BR/194/21/HH

21 West Street Bognor Regis PO21 1XA

Erection of first floor home office above existing outbuilding. This application may affect the character and appearance of The Steyne, Bognor Conservation area. This application may affect the setting of a Listed Building.

Drawing Title
EXISTING +
PROPOSED DETAILS

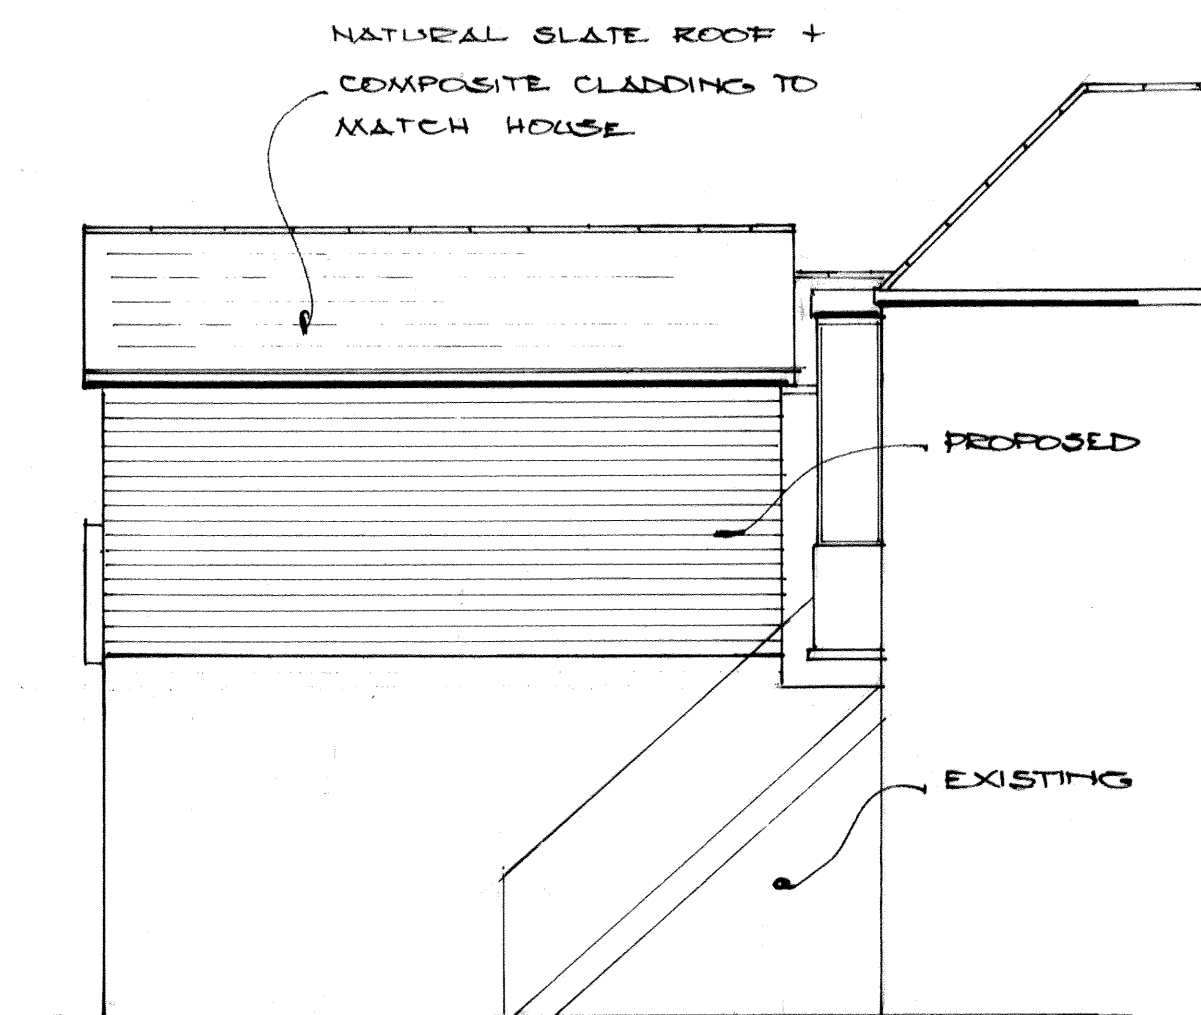
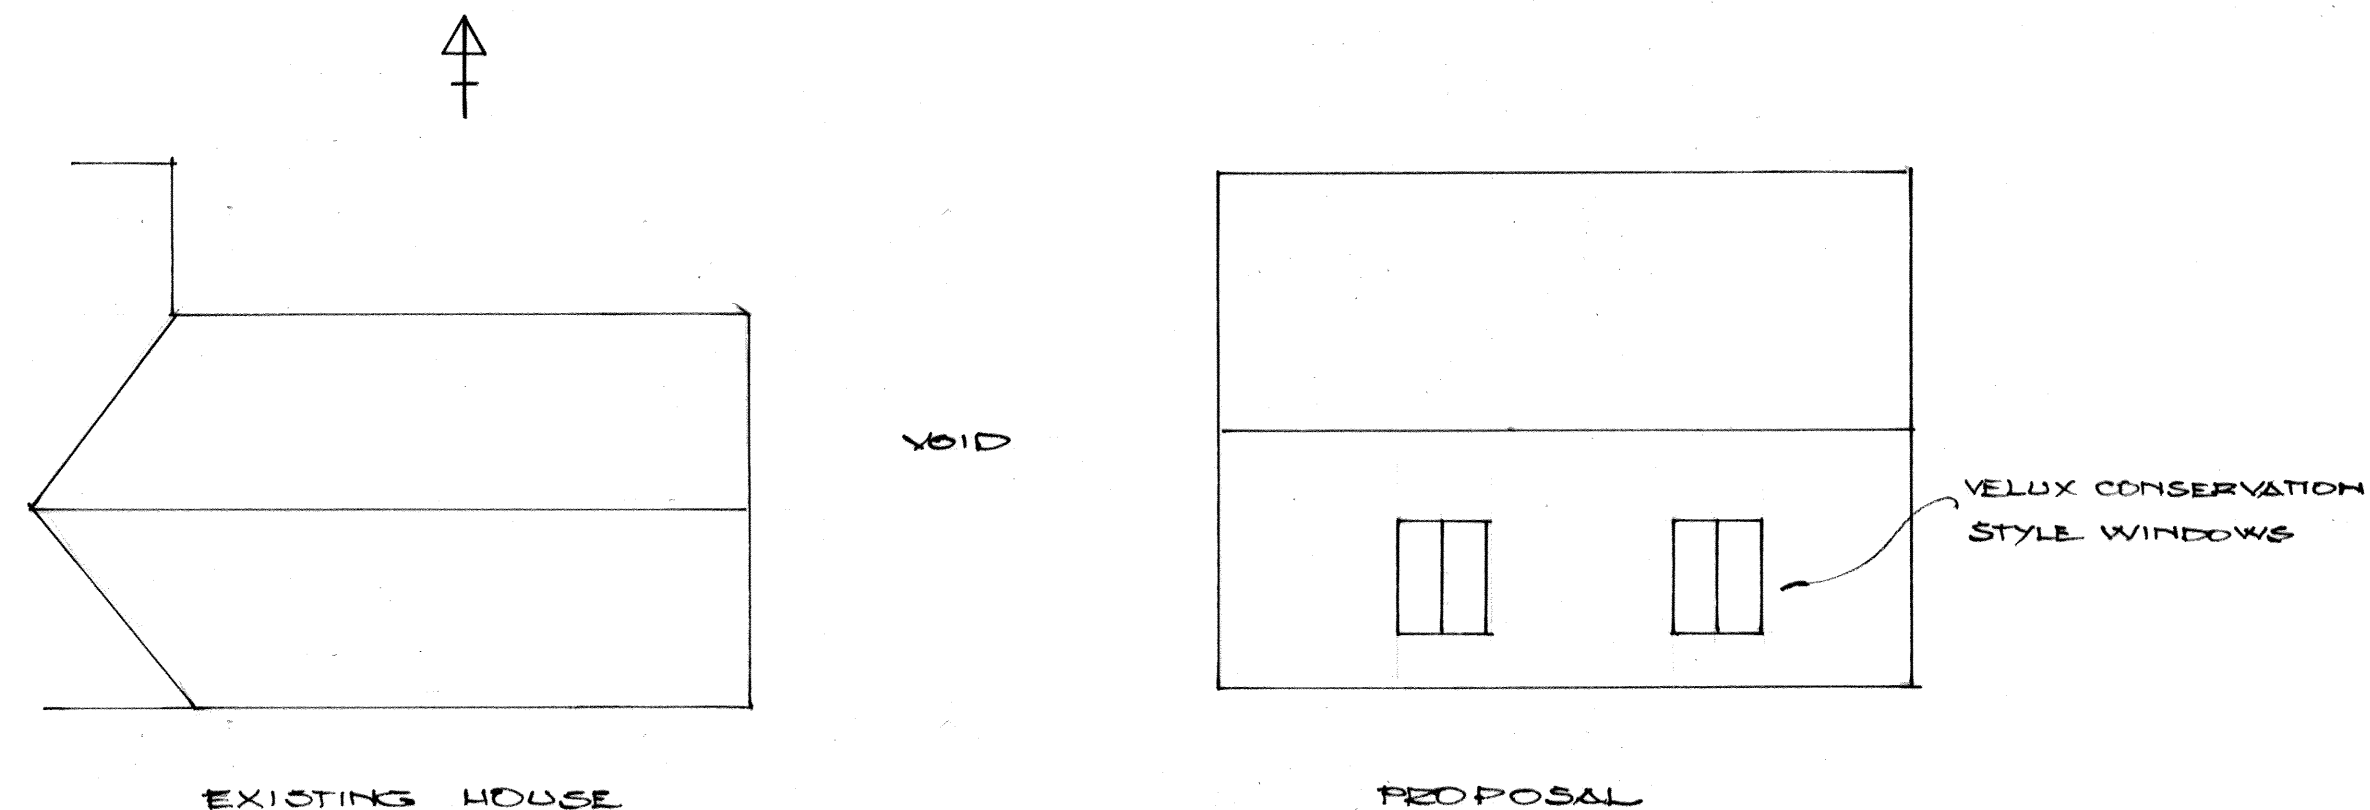
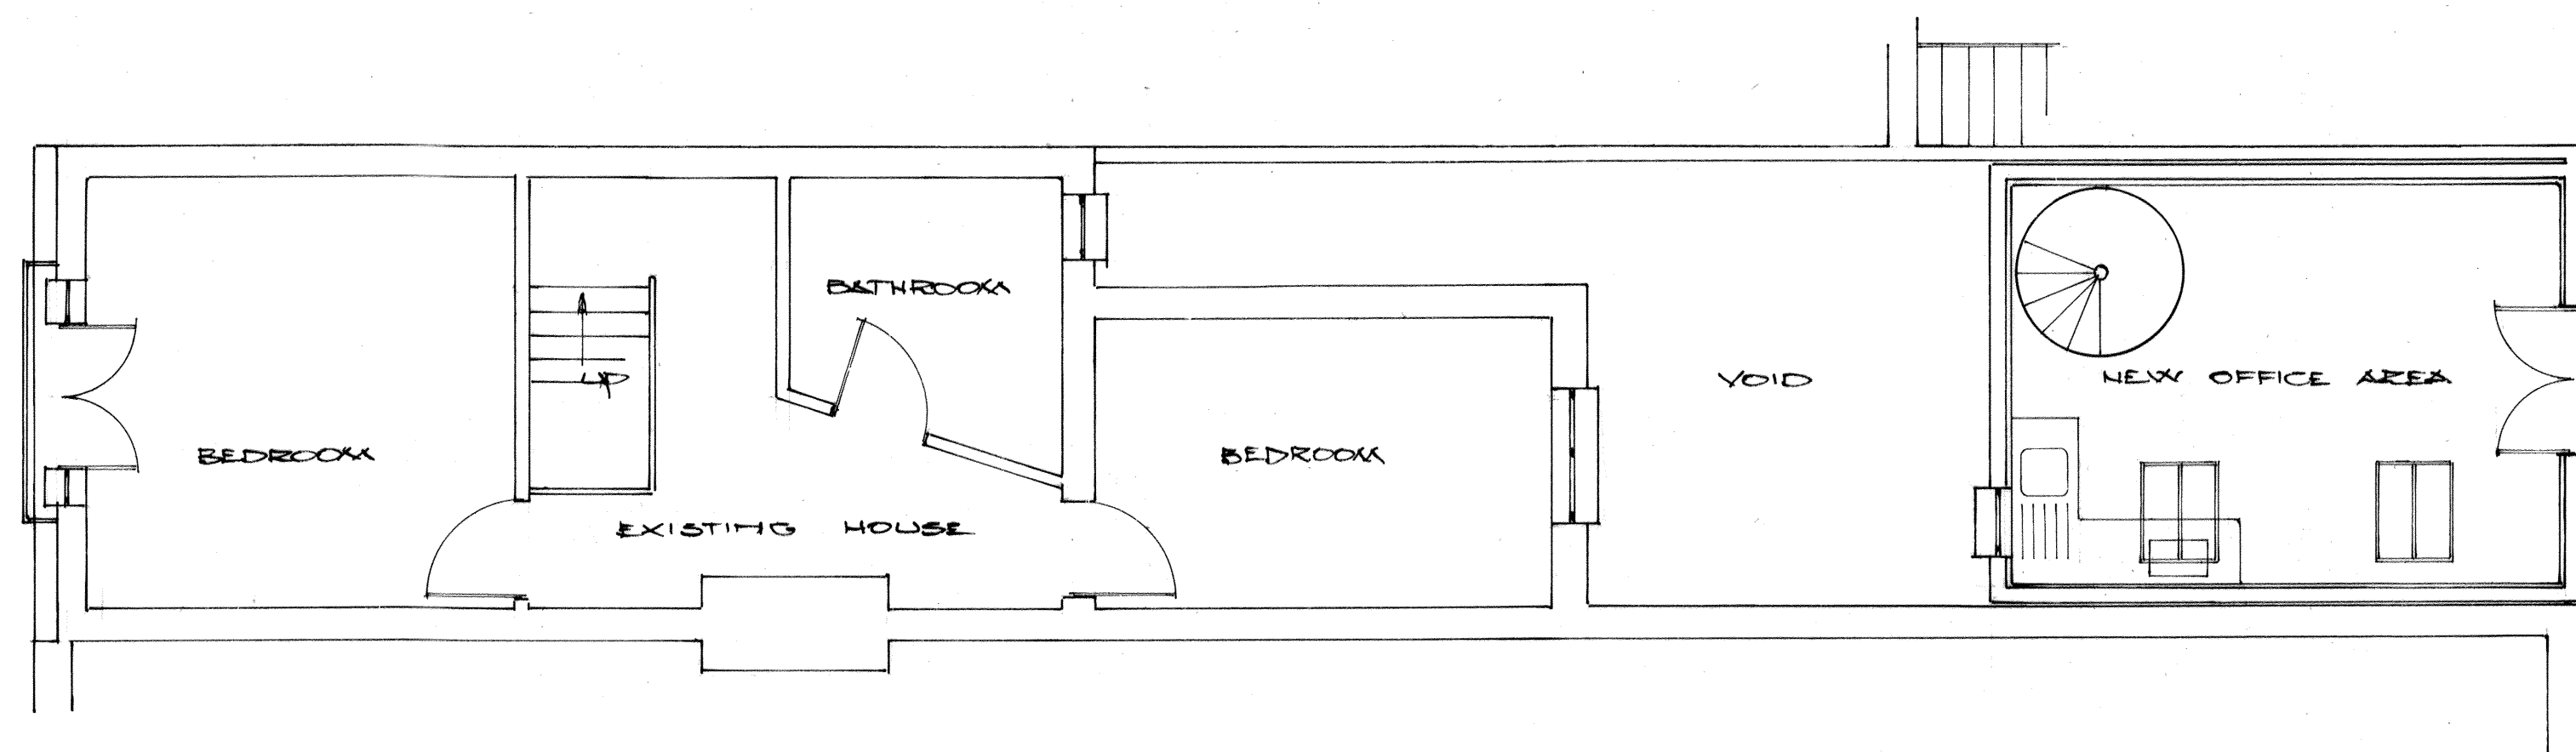
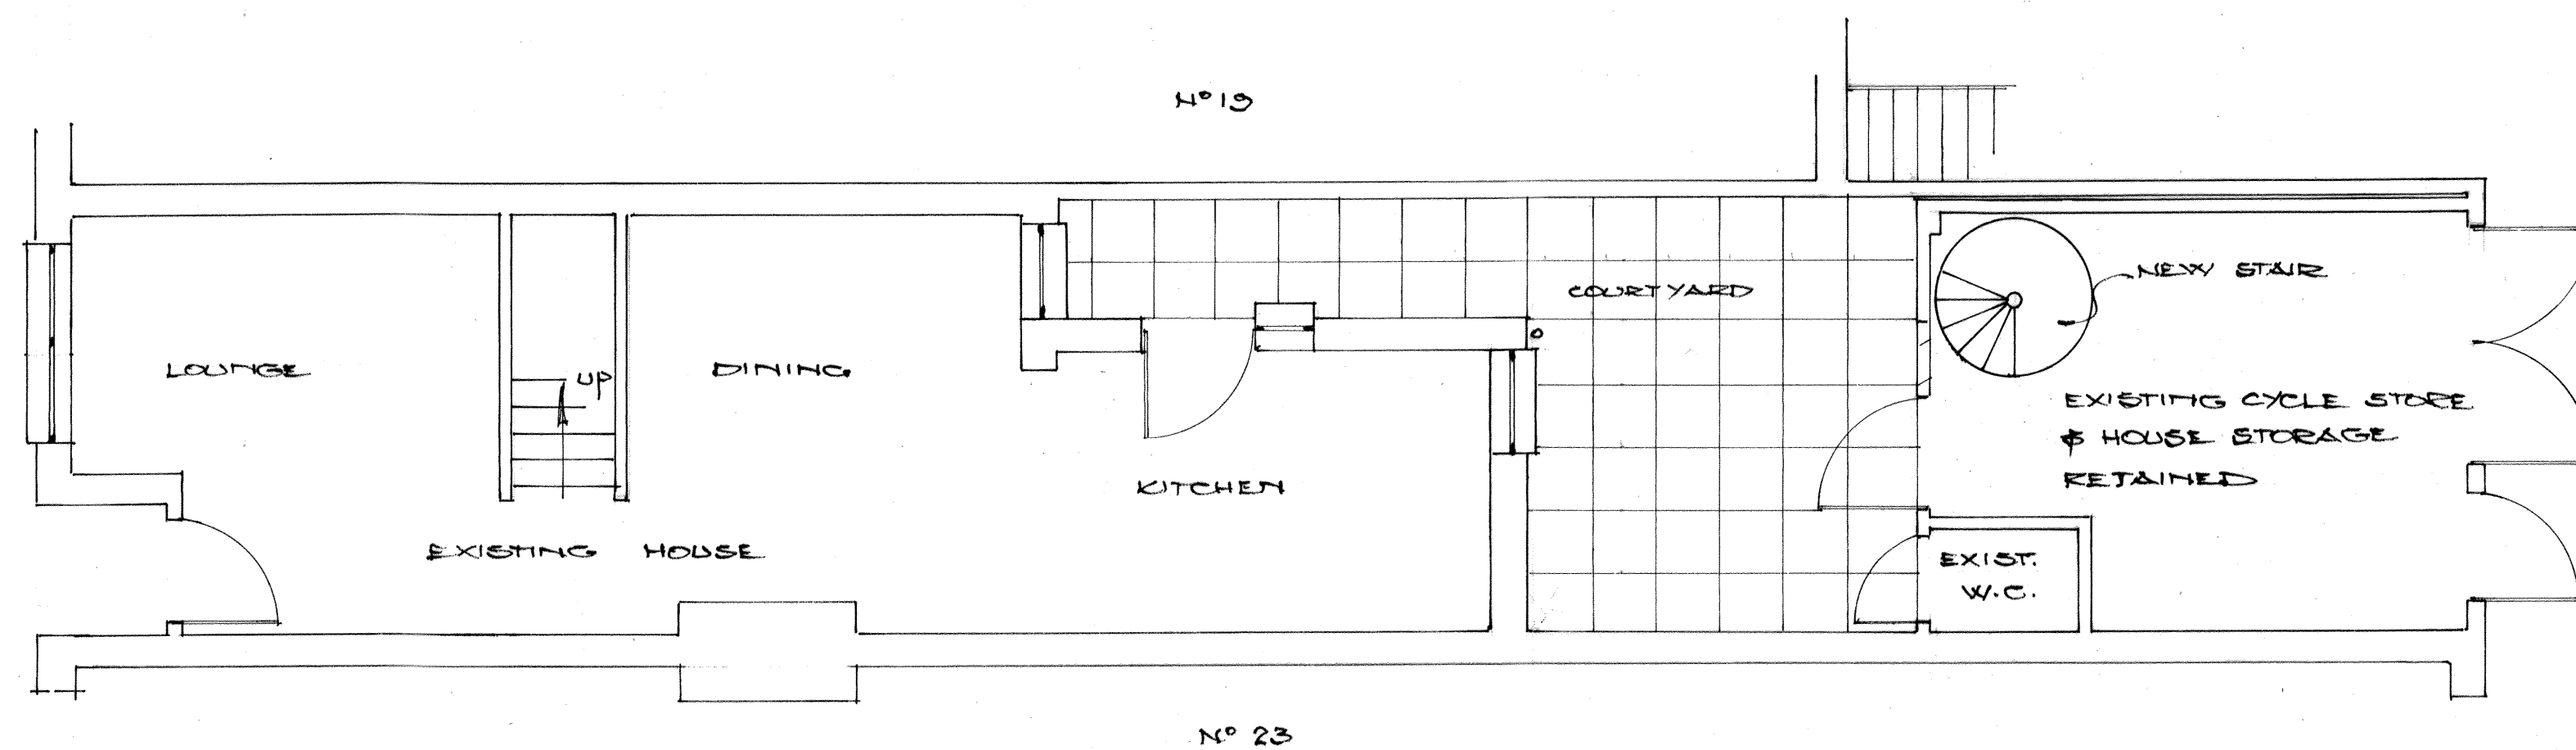
I note from the plans that the roof will be natural slate and there will be two conservation style rooflights, both of which are positive features. The development would also help to improve the condition of the area and hopefully encourage other improvements along the street. The only area of concern relates to the proposed materials for the exterior walls and windows. The first floor would be clad with a modern material; cream composite cladding. A review of those buildings in the street has identified that the majority of them appear to be rendered and painted as opposed to clad. The use of such material would therefore be out of character with the remainder of the street. However, it would appear to reflect the rear elevation of the existing main dwelling. Whilst this might be the case, I believe that something more in keeping will help to reflect the character/appearance of the street, whilst also allowing for it to evolve and improve.

It would appear that the intention is for the windows and French windows to be UPVC. UPVC is not a traditional, vernacular material and is unsuitable for use in historic buildings. Such windows are often crudely detailed, and the size of frame is usually much larger than that of a traditional window, giving them an obtrusive, 'chunky' appearance. The 'shiny' finish of uPVC is also out of keeping with traditional materials. The use is therefore not appropriate for a conservation area.
